WEST SUSSEX COUNTY COUNCIL CONSULTATION

TO:	Arun District Council FAO: Mrs A Gardner
FROM:	Highways, WSCC
DATE:	01/08/2018
LOCATION:	Land At Asda Superstore, Littlehampton Road, Ferring, BN12 6PN
SUBJECT:	FG/105/18/PL Installation of a six-pump (12 filling position) automated petrol filling station ('PFS') & associated works. Resubmission of FG/206/17/PL.
DATE OF SITE VISIT:	n/a
RECOMMENDATION:	☐ Advice ☐ Objection ☐ Modification ☒ No Objection ☐ More Information ☐ Refusal
S106 CONTRIBUTION TOTAL:	n/a

Location Entrance to petrol filling station.

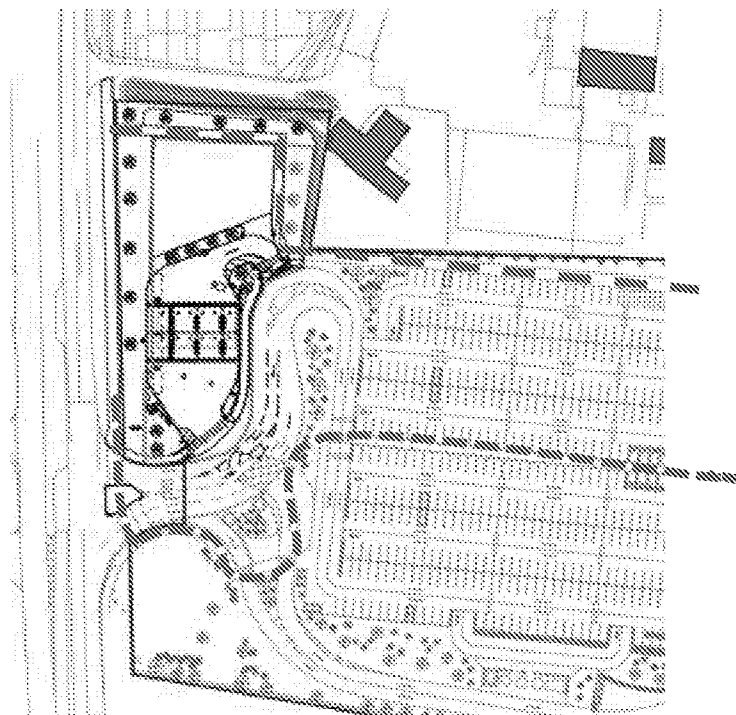
A Stage One RSA has been submitted in support of the application. Only one problem has been raised pertaining to pedestrian movements across the internal access point for the Petrol Filling Station.

It has been recommended that the footway at the eastern side of the access road between the signalised junction (A259) and along the frontage of the petrol filling station is removed and pedestrian are signed to the store via a footpath at the eastern boundary and the footway network west of the junction.

The designer has accepted the Safety Auditors Recommendations and the latest suite of plans provided, in principle, demonstrate the recommendations to the satisfaction of the Local Highways Authority. The Auditors recommendations make reference to signage for pedestrians. I note this has not been demonstrated but as the applicant has accepted the Auditors recommendations I would be minded to accept the details of this signage can be secured via a suitably worded planning condition.
